RE: Notice of Incompleteness for File No. CAO19-015 – Klein Critical Areas Determination  
74XX SE 38<sup>th</sup> Street, Mercer Island, WA 98040; King County Tax Parcel # 362350-0226

The City of Mercer Island received the above referenced application for a Critical Area Determination to build a new single family residence that requires a steep slope alteration for the property located at 74XX SE 38<sup>th</sup> St (King County parcel # 362350-0226) on June 26, 2019. The City has assigned file number CAO19-015 to the permit application. Following review of the application, City staff has determined that the application is not complete.

PAVING AND GRADING PLAN & PROFILE

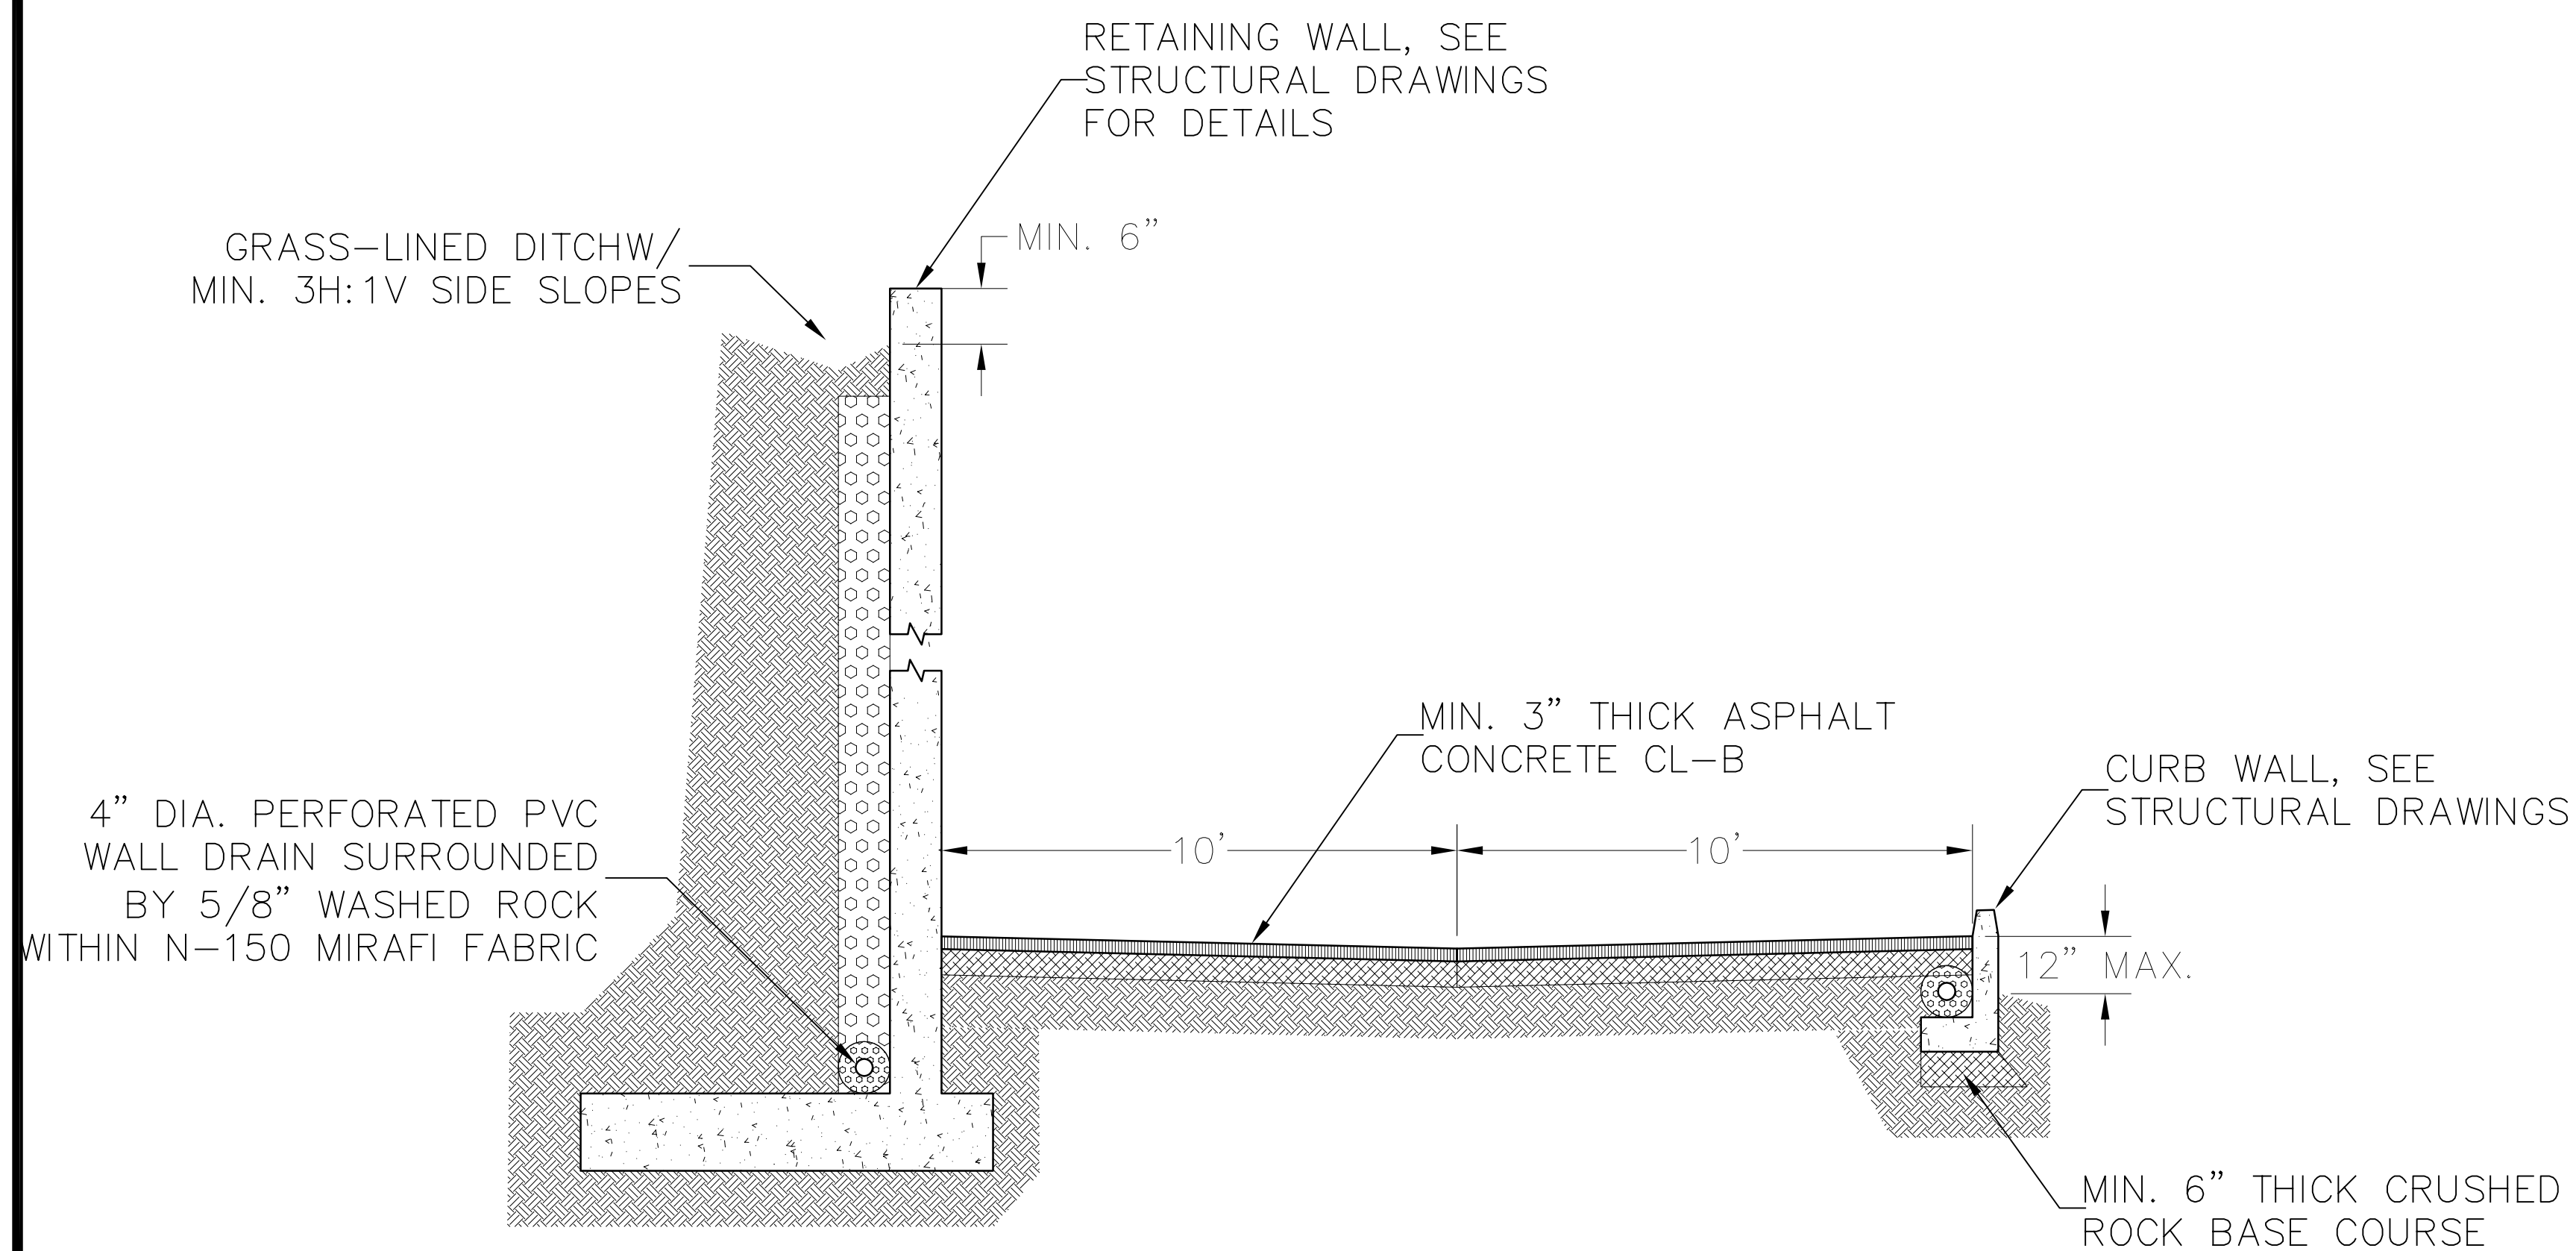
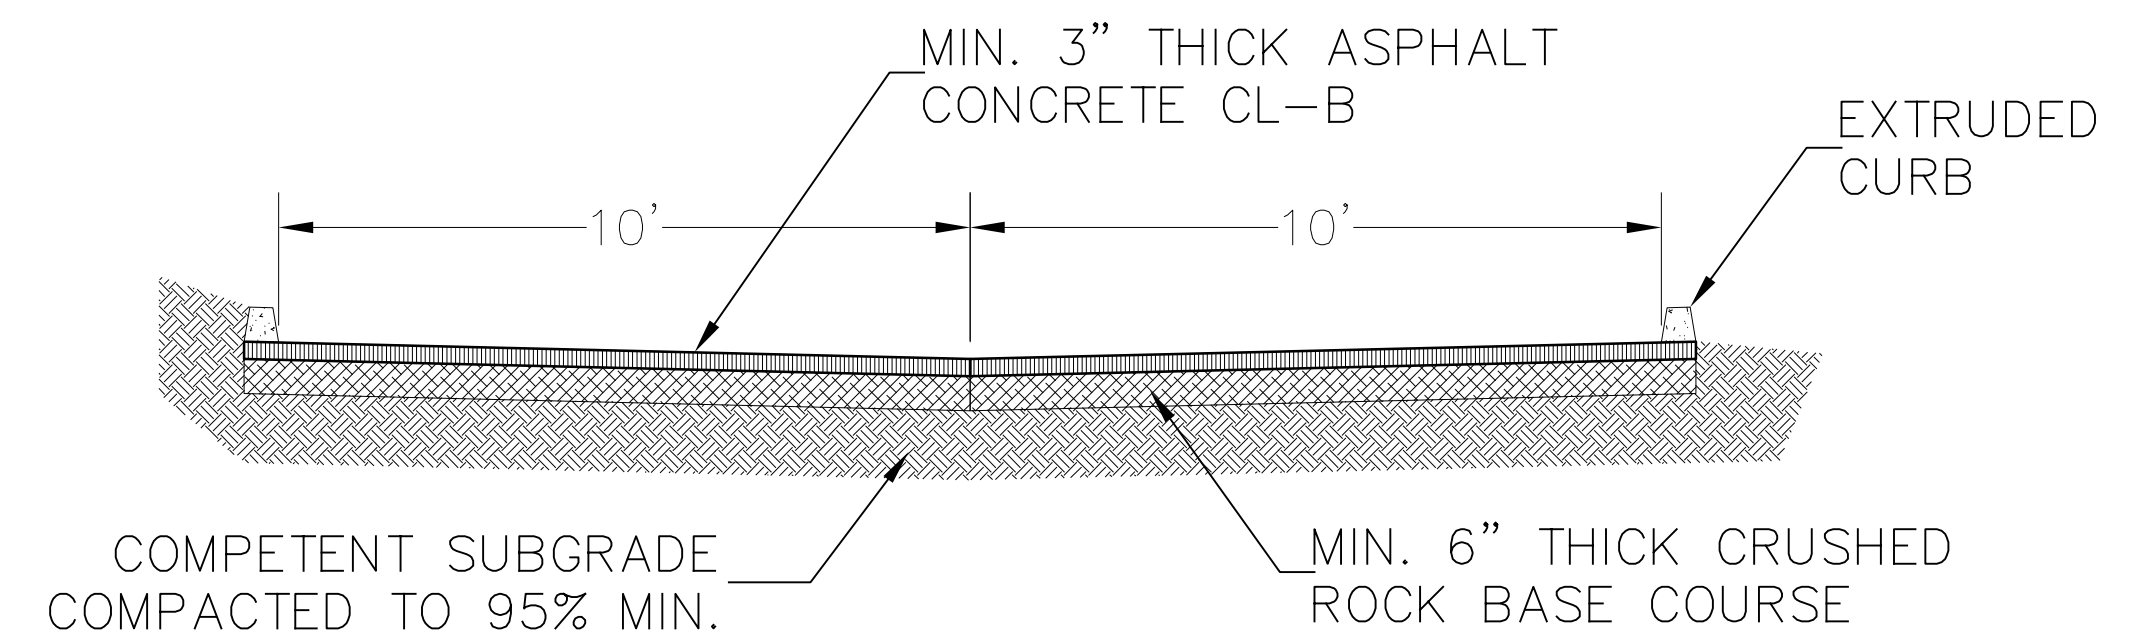
- a. The Fire Department must approve the access to the site.
- b. A turn-around must be added to the base of the driveway to be compliant with fire access or mitigation and a code alternate will be required to be approved as a condition of building.
- b. It appears significant work is occurring beyond the property boundaries. Approval from the owners or City is required prior to approval.
- c. An applicant paid geotechnical peer review is required.
- d. Conventional cantilevered retaining walls do not appear to be appropriate for this site.
